**Consultation Response from KC,
Highways Development Management**

2024/91927 Grange Nurseries, North View Road, East Bierley, BD4 6NS

Erection of extensions and front and rear dormers, alterations to dwelling and formation of private access road

Date Responded: 23/01/2024.

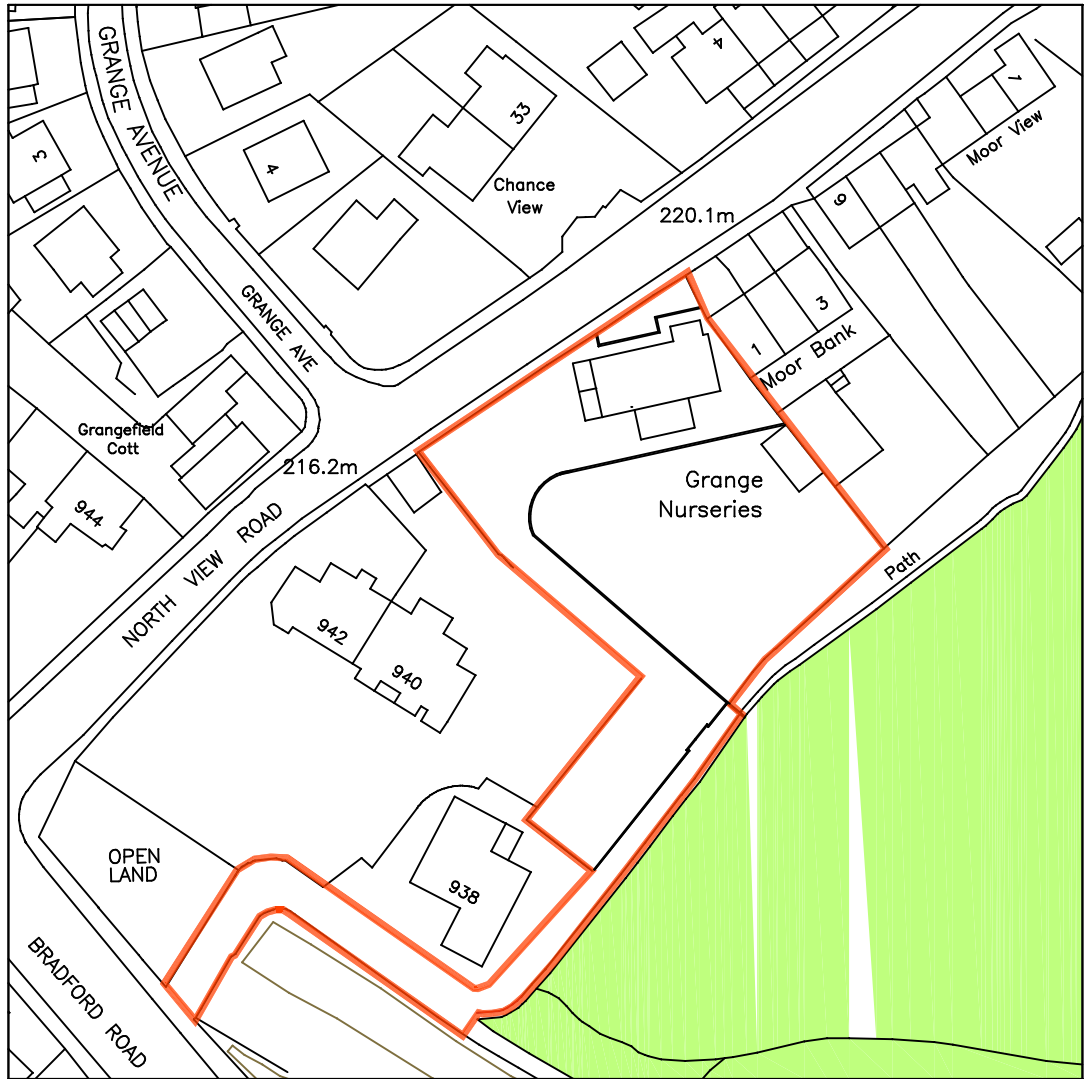
Vehicular access is proposed from A651 Bradford Road via an unnamed and unadopted public footpath No SPE/8/5 and SPE/8/60. although no specification for the driveway

The existing vehicle access from Bradford Road currently serves three existing properties. However, beyond the entrance to Willow Grange Care home the route of the proposed access reduces to an unmade footway of approximately 1m wide and is unsuitable for vehicles.

Also does the applicant have vehicular rights of access from this footpath.

CLIENT	MR AND MRS S, O'BRIEN 34 THORNEDENE WAY, TONG, BRADFORD BD48NW.		
PROJECT	REFURBISHMENT OF BUNGALOW AT GRANGE NURSERIES WEST GATE HILL TONG BRADFORD BD4 6NS		
DETAIL	EXISTING AND PROPOSED BLOCK PLAN OF FULL AREA		
SCALE	1=1000 1=200	DATE	JULY 2024
DRAWN BY	AH	DRAWING NO	O' BRIEN FILE D3

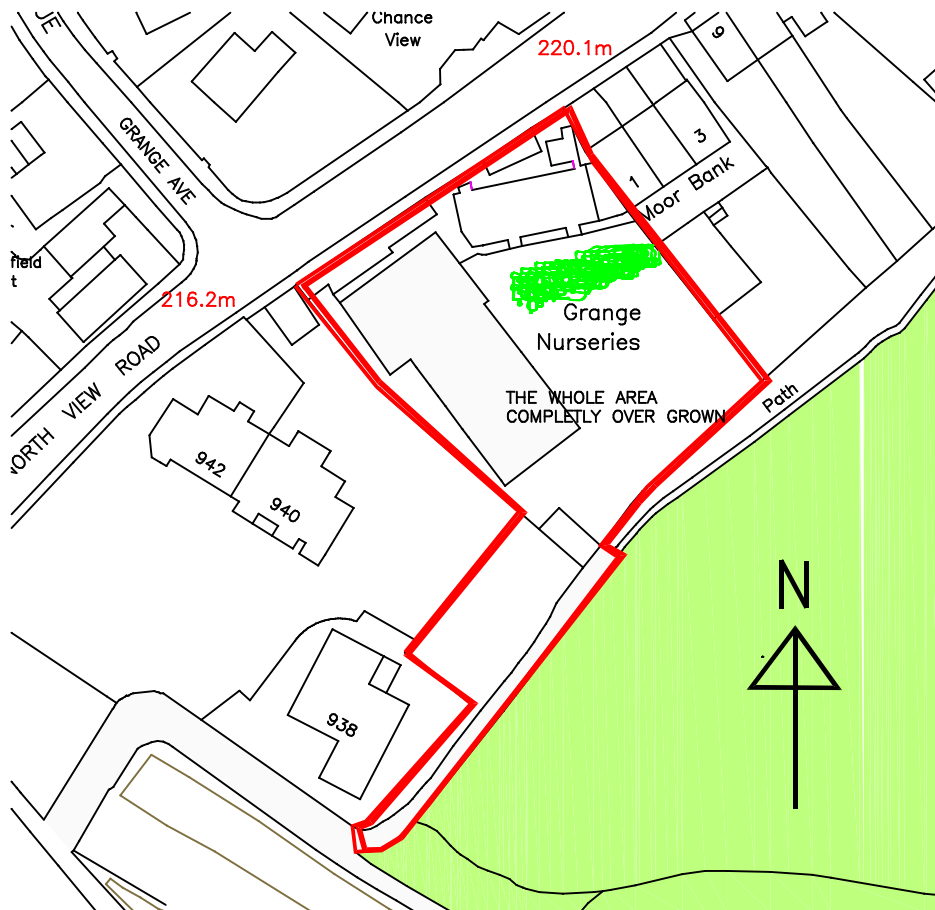
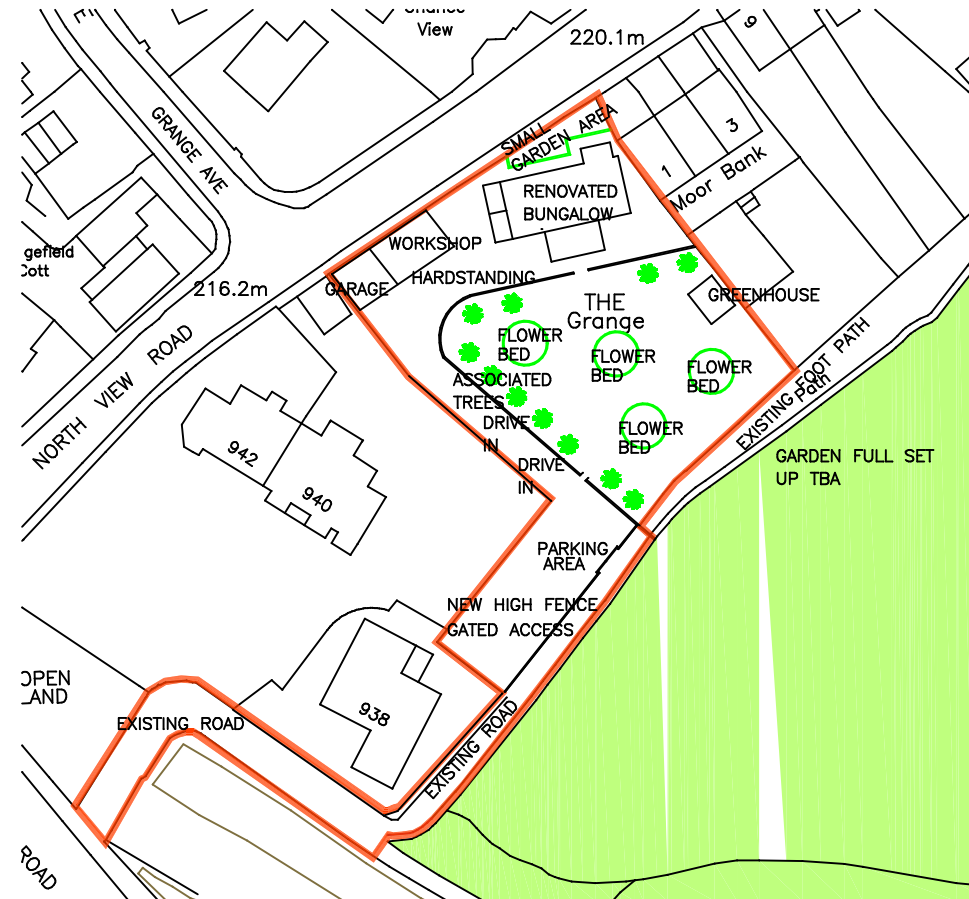
The proposals will not increase the number of parking spaces required for this dwelling and are acceptable. However, the proposed vehicle access cannot be supported and should be removed from the application.

Significant improvements to this section of the footpath, from the entrance to Willow Grange to the proposed access to the site, would be required. Including the widening of the footpath to 4.5m, forward visibility around the bend and reconstructing the surface to ensure it can accommodate vehicles safely.

Without the above improvements, the proposal will intensify the use of this substandard footpath and would be detrimental to highway safety at this location and could not be supported by Highways Development Management.
